Requested Amendments to Response to Submissions agreed on 23 March 2016 with the Department of Planning & Environment

### Indicative Site Plan Dimensioned

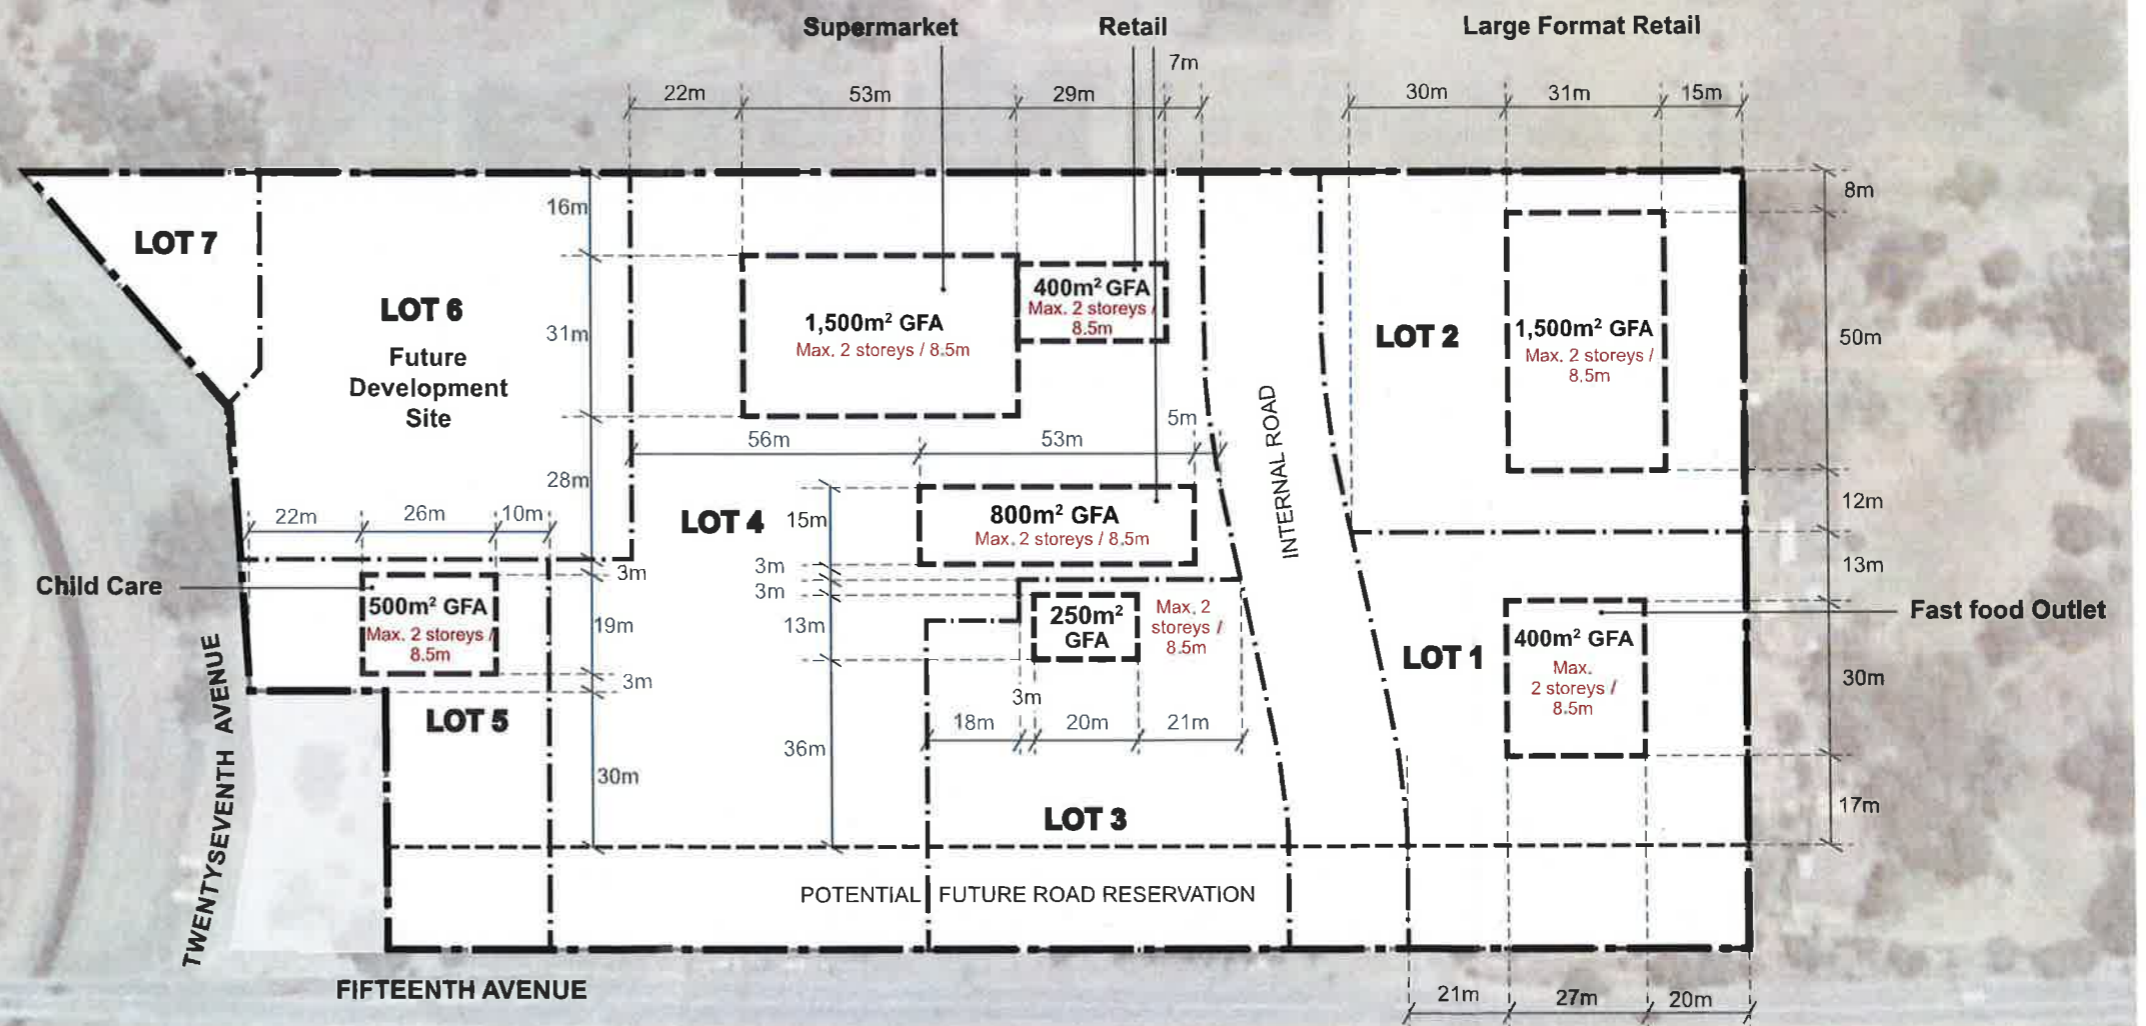
Item	Action
1. Building Envelopes	Block Plan (not illustrative) required illustrating <u>indicative/maximum</u> building footprint, heights, setbacks and GFA for each building. Updated Site Plan provided in Appendix 1.

3. Landscaping and Parking Setbacks	Design guidelines to be provided for landscaping and parking setbacks from Fifteenth Avenue in recognition of future road widening. - Site Plan (Appendix 1) illustrates 5m setback from estate road; and 10m setback from future upgrade/widening of Fifteenth Avenue. - Design Guidelines (Appendix 2) imposes setback requirements.
